**KIRKLEES METROPOLITAN COUNCIL
INVESTMENT & REGENERATION SERVICE**

DELEGATED DECISION TO DETERMINE PLANNING APPLICATIONS

Reference No:	2022/62/90404/E
Site Address:	8, Ashbourne View, Cleckheaton, BD19 5JE
Description:	Erection of three storey rear extension
Recommending Officer:	Elenya Jackson

DECISION – CONDITIONAL FULL PERMISSION

Drawing No. 166/04

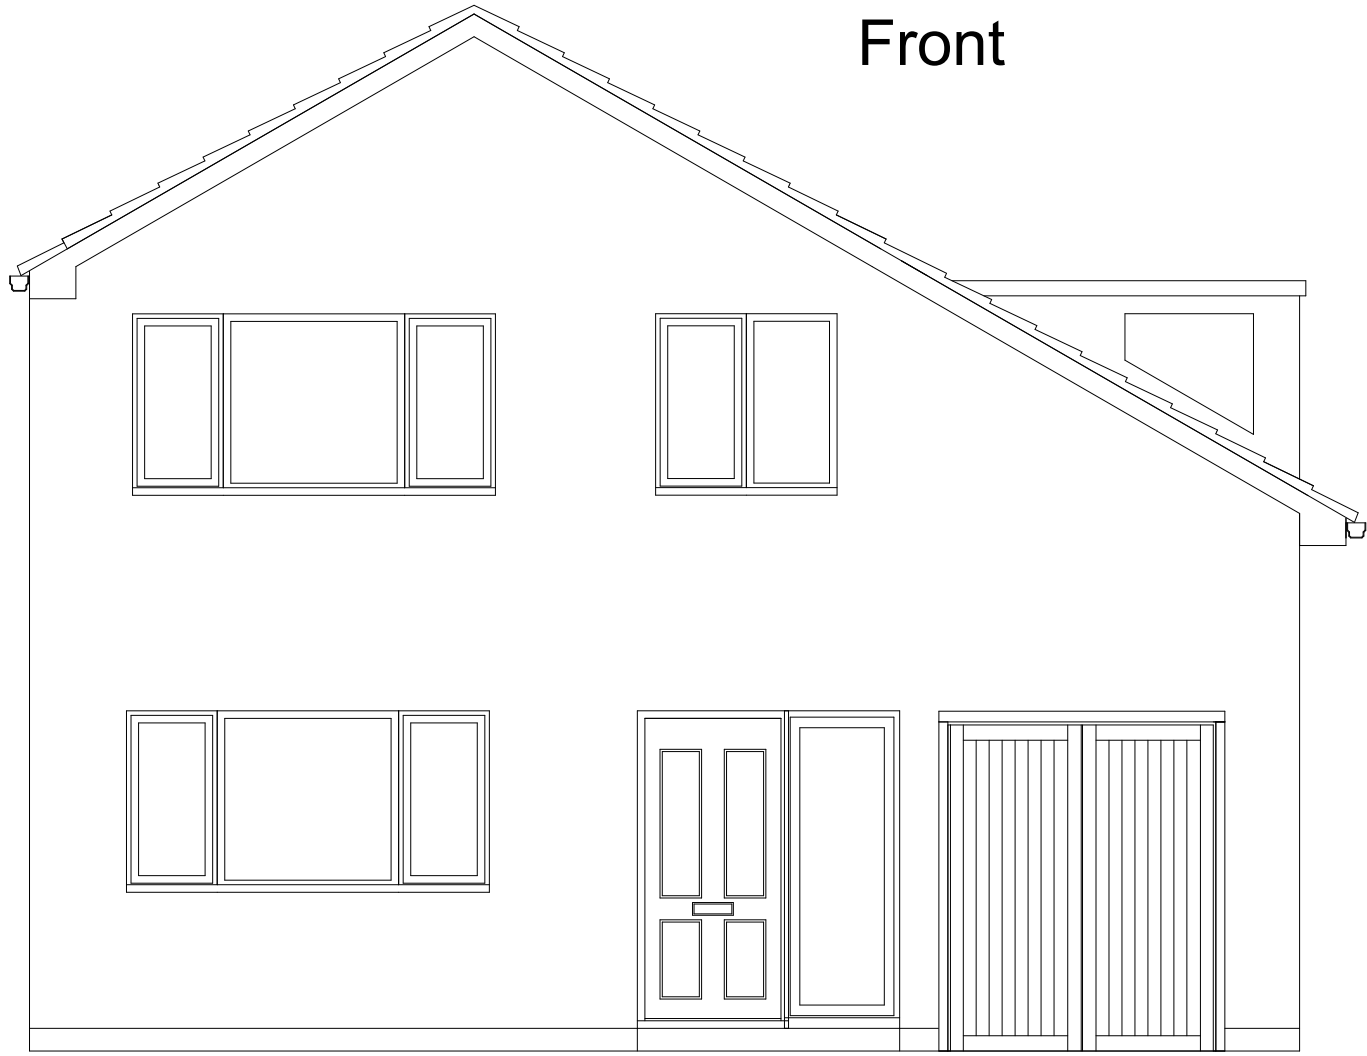
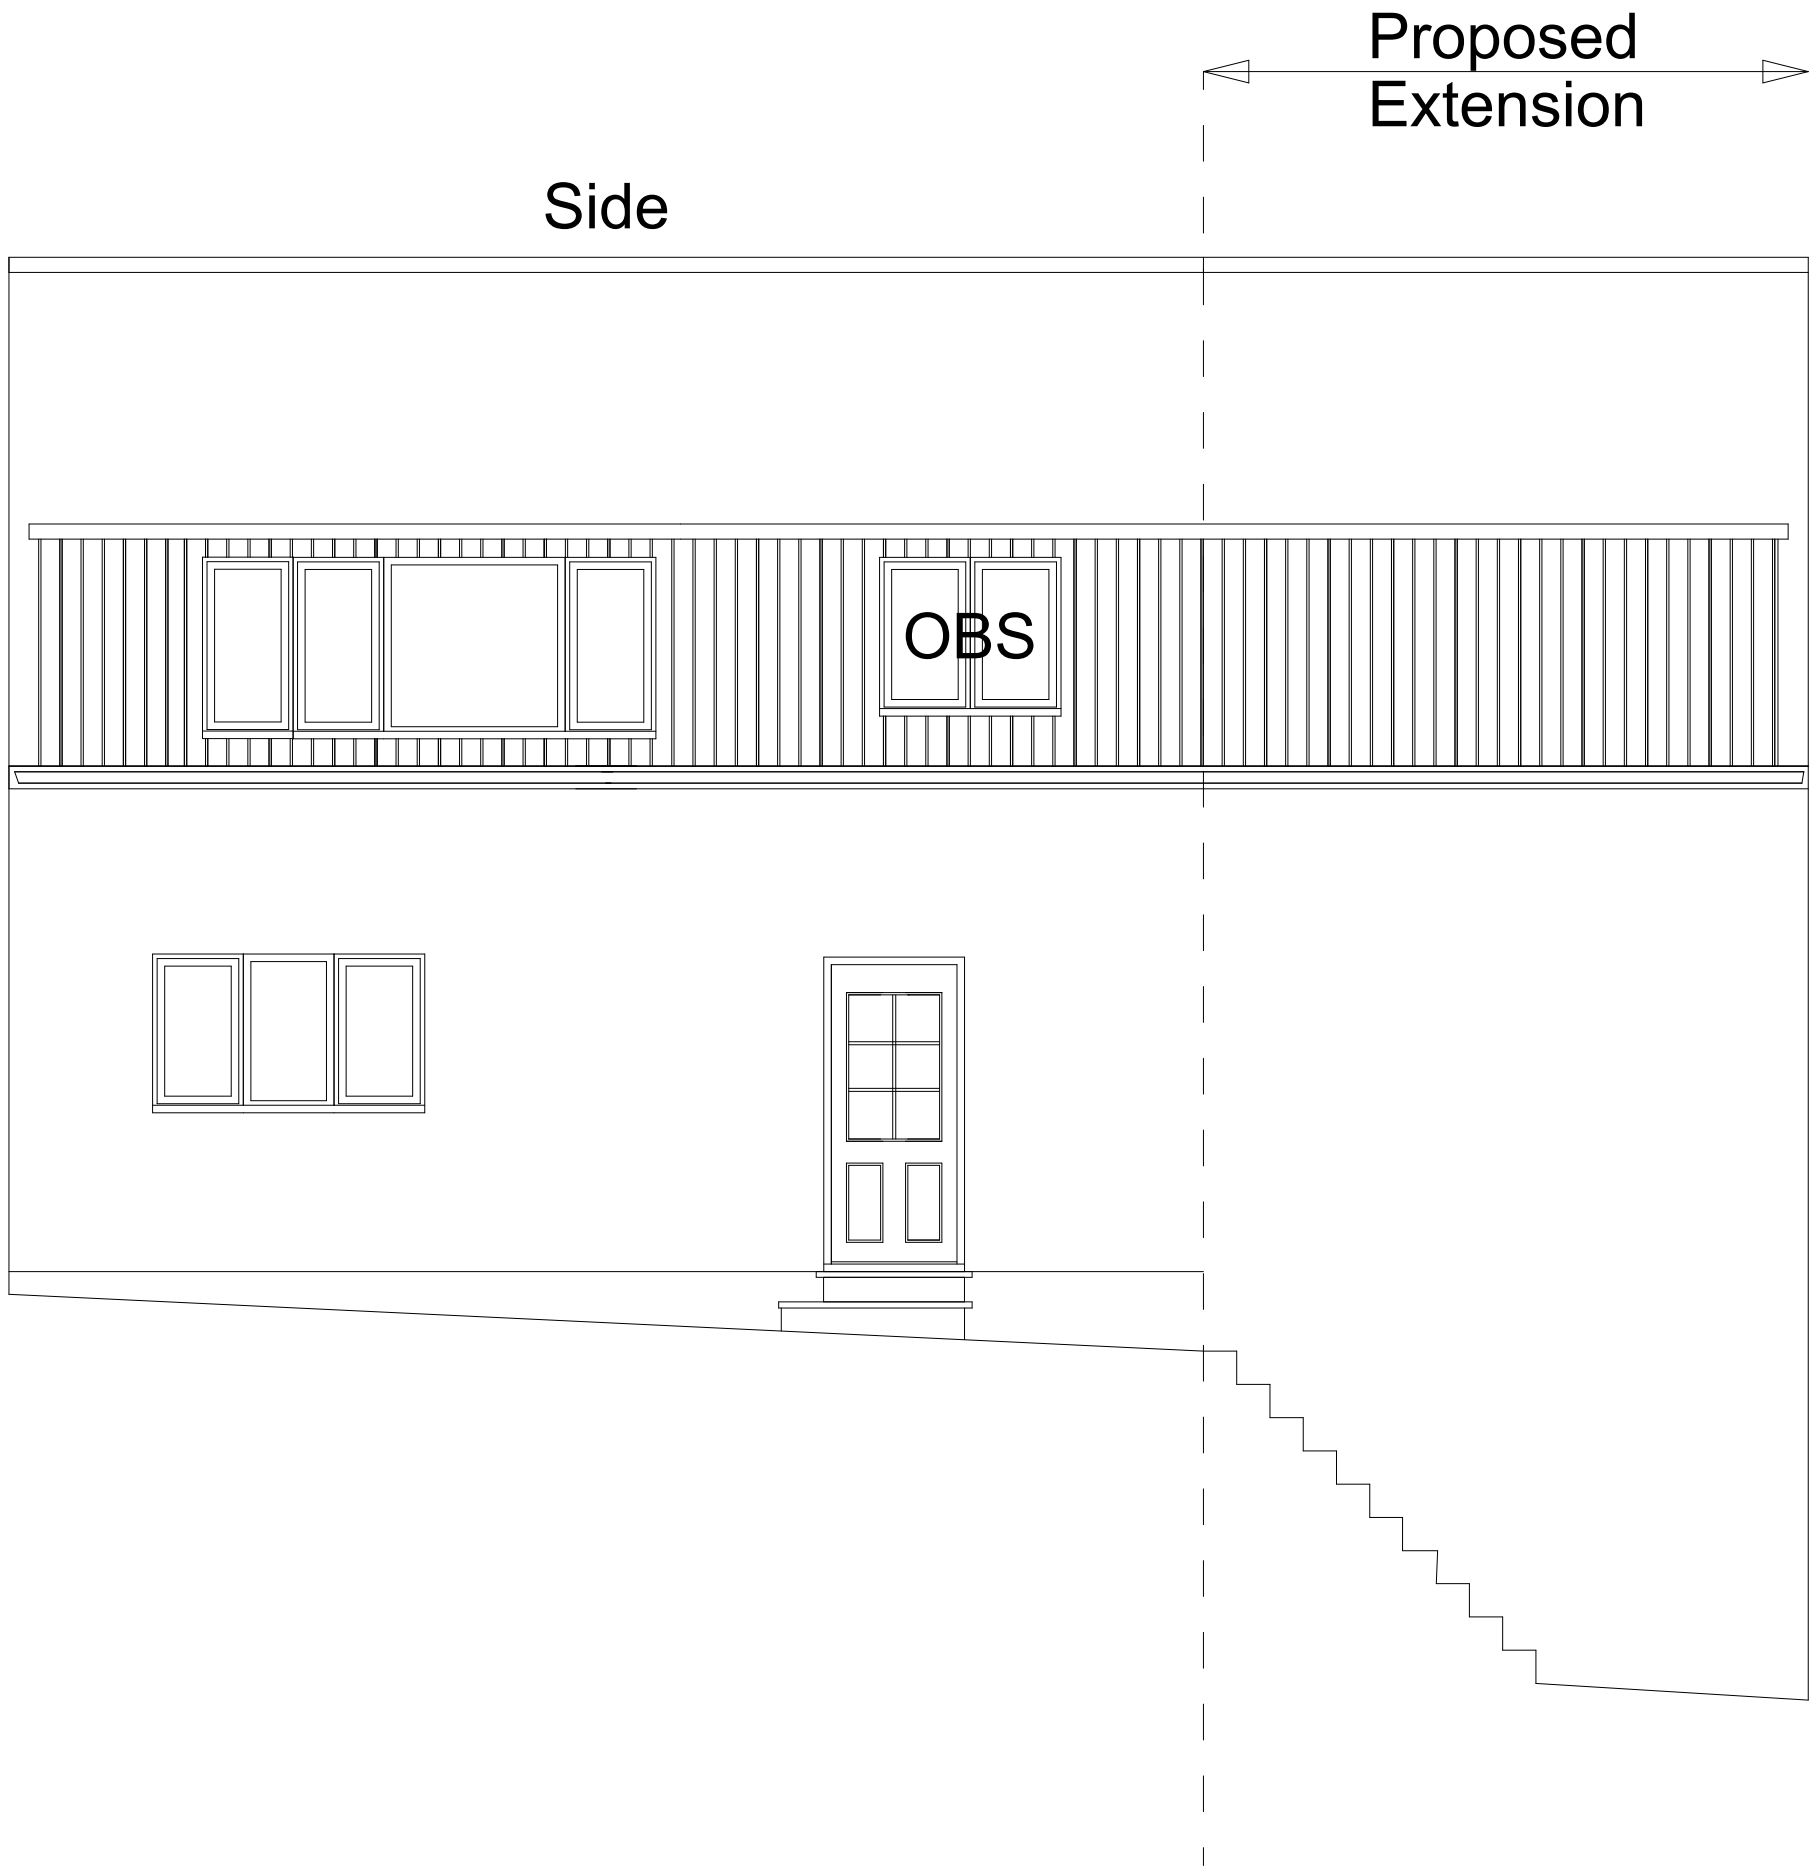
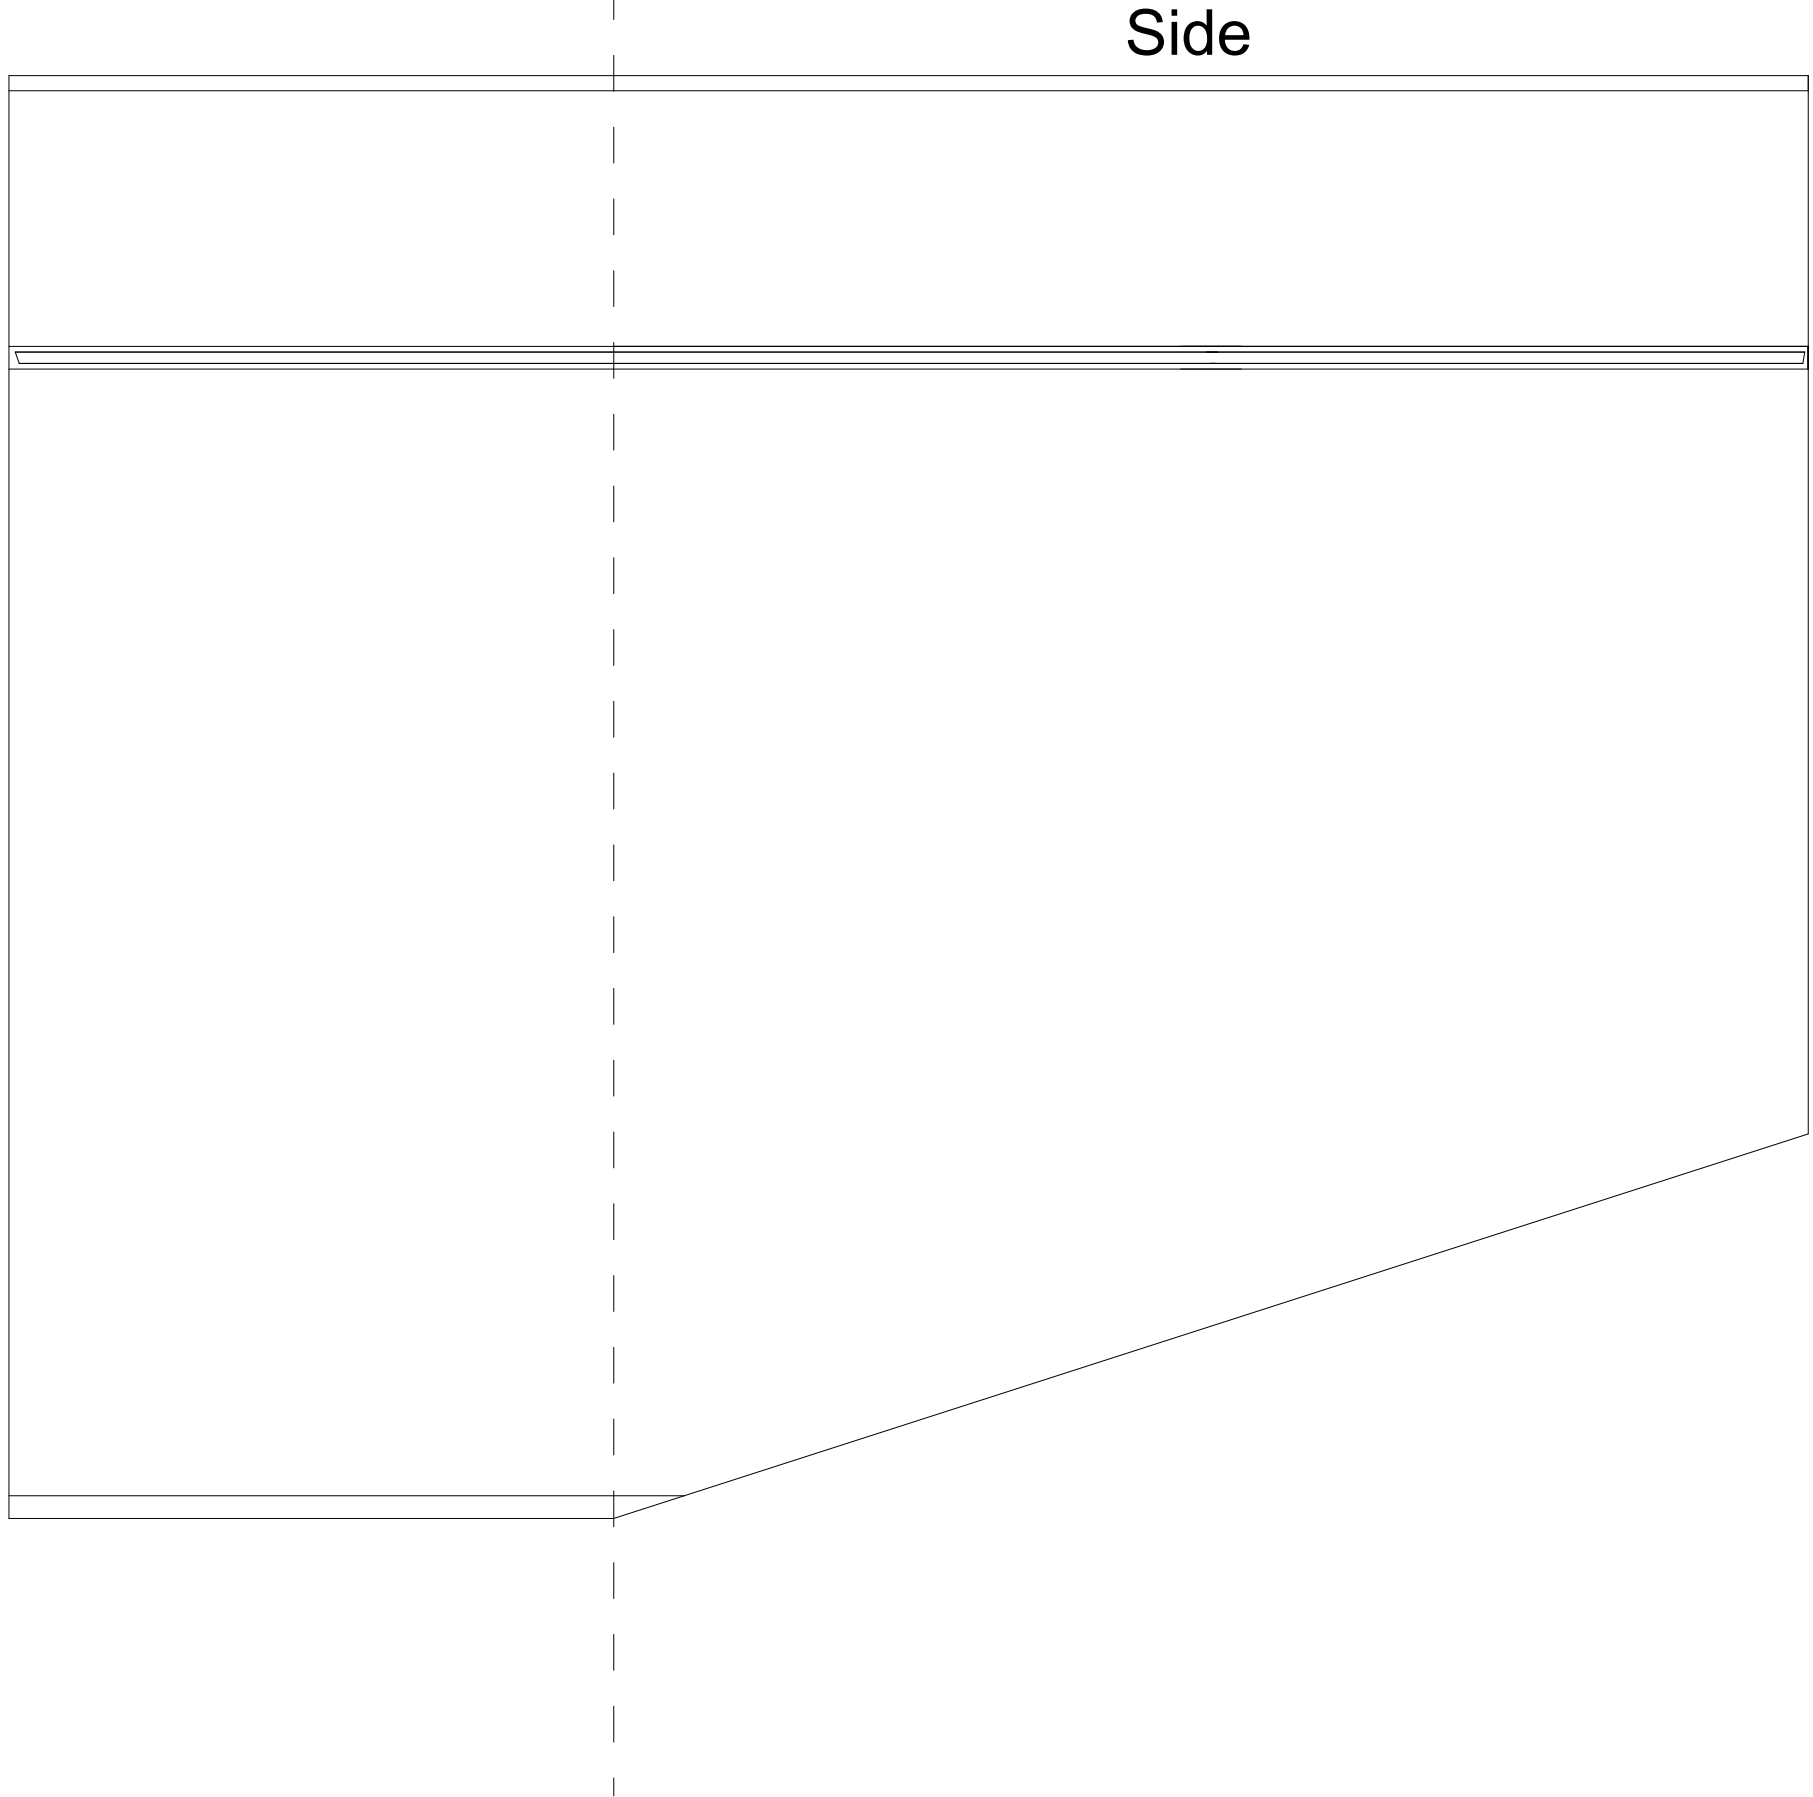
The side element of the proposal would have a width of 8.3m, a depth of 4m a maximum height of 9m and an a symmetric eaves height of 8m along the western boundary and 6m along the eastern boundary (matching the existing dwelling).

The proposal would feature a gable end matching the existing dwelling and would be constructed with all external facing materials matching the existing dwelling.

The proposal would also feature an extension to the existing dormer on the eastern elevation of the property. This would increase the length of the dormer by 3.8m towards the rear of the dwelling.

The scale is considered acceptable projecting 4 metres from the rear of the existing detached dwelling. This meets the guidance contained in the House Extensions and Alterations SPD applied to two storey extensions and is considered appropriate to apply to this development.

The proposal would be constructed out of materials matching the existing dwelling, retains the characteristics of the existing dwelling (such as the asymmetric eaves), and would not alter the properties appearance within the street scene.

Overlooking: The proposal would feature one additional side facing window relating to a bathroom. As this could be conditioned to feature obscured glazing, no significant issues would be raised regarding overlooking.

Overshadowing/loss of light: The proposal would not reside within the horizontal 45 degree visibility of the rear facing windows at no.6 or the vertical. Therefore, no significant issues would arise regarding loss of light to any habitable rooms at no.6. The proposal would be situated to the west of no.6, due to the location of the proposal it is acknowledged that there would be the potential for an overshadowing relationship for the occupiers of no.6; however, due to the orientation (the rear of the dwellings face north) and separation of the dwellings, the existing dwelling creates an overshadowing relationship and any increased overshadowing would be for a limited period. Therefore, the proposal would not raise any significant issues regarding overshadowing.

Overlooking: The proposal would not feature any side facing windows.

Overshadowing/loss of light: The proposal would not reside within the horizontal 45 degree visibility of the rear facing windows at no.10 or the vertical. Therefore, no significant issues would arise regarding loss of light/overshadowing to any habitable rooms at no.10. Due to the proposal being situated to the east of no.10, it is considered that no significant issues would arise regarding overshadowing.

4. Notwithstanding the provisions of the Town and Country Planning (General Permitted Development) Order 2015 as amended (or any Order revoking or re-enacting that Order) no doors, windows or any other openings shall be created in the either side elevations of the extension hereby approved.
